From: [Dusty Pilkington](#)
To: [Eric Trygstad](#)
Subject: RE: BL-18-00006 Garrison
Date: Wednesday, May 16, 2018 1:25:55 PM

Please review this Boundary Line Adjustment (BLA) application, BL-18-00006 Garrison, and submit comments for the decision. Control Click on the hyperlinks below. Comment period for this application ends on **05/31/2018**.

# BLA EXHIBIT

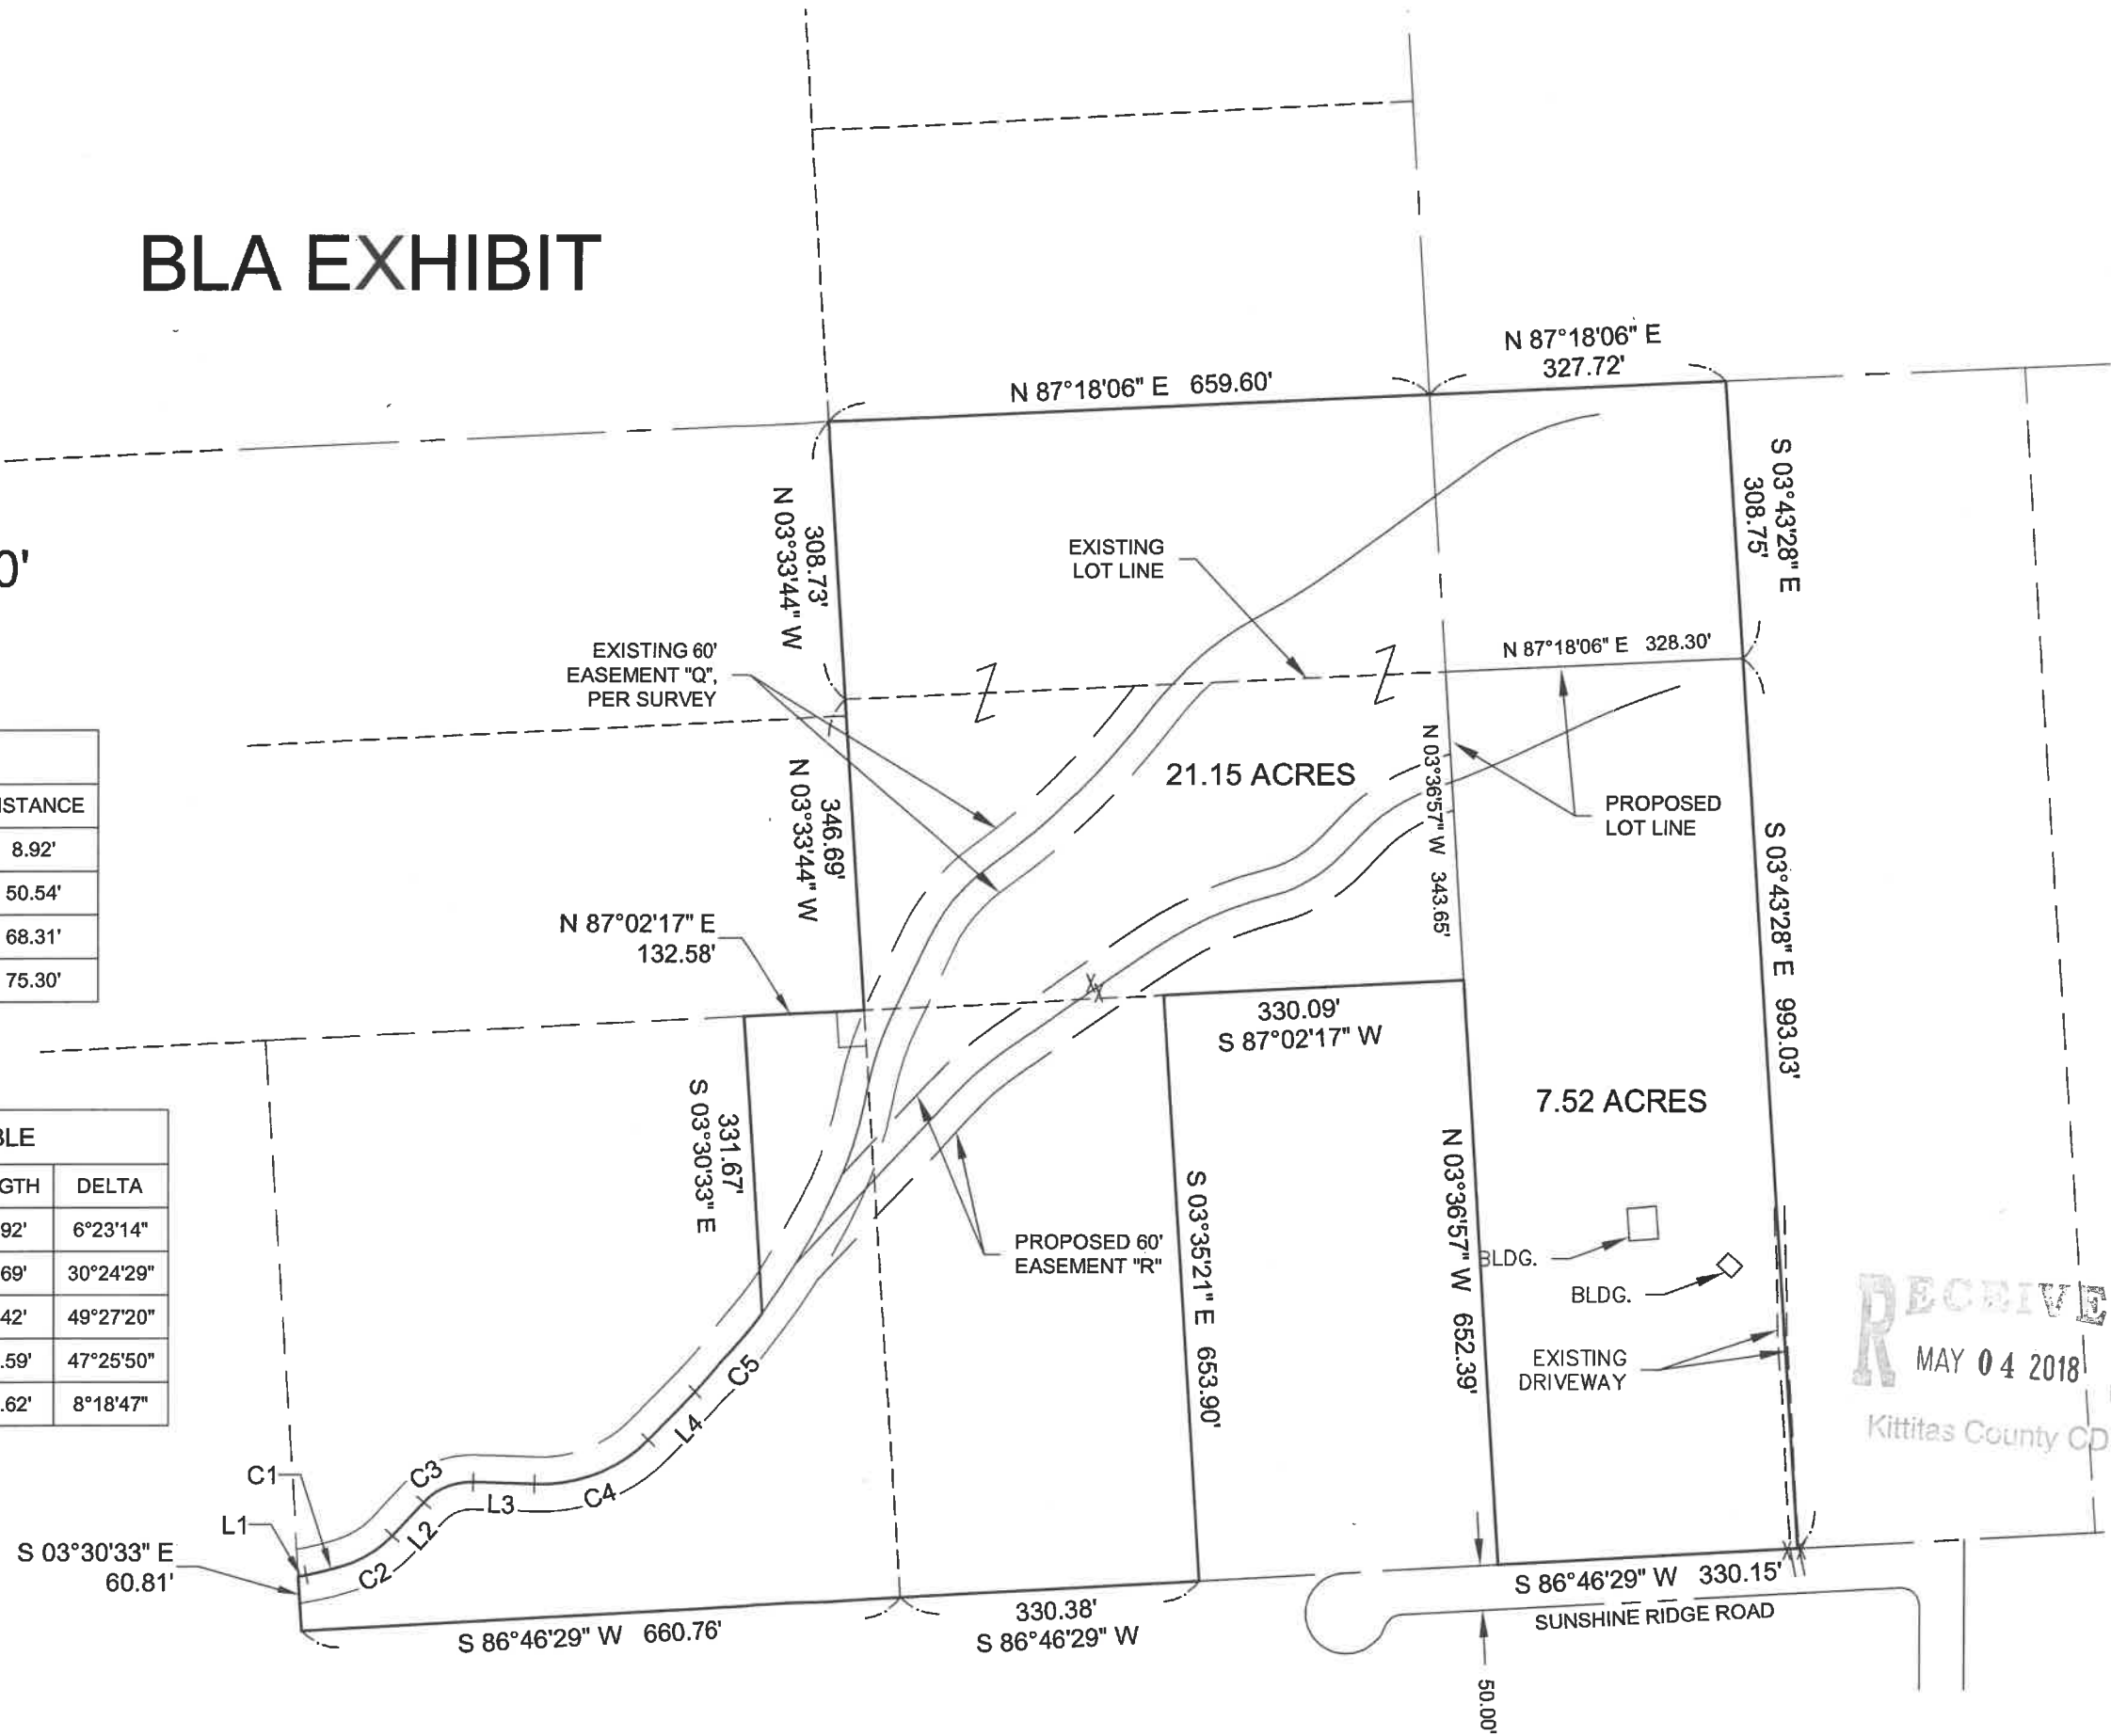
I have reviewed this and feel that as long as Pub Works has no issues, I'm good with it. Does it meet all of the WUI requirements? The reason I mention this is because the map shows a "proposed" easement, but the aerial looks as though it's already done. If it's simply a lot-line adjustment, and the easement map was simply for reference, then I don't have an issue with it.

I will forward your message to the applicant, at the end of the comment period, and this will allow them to clarify the easement.
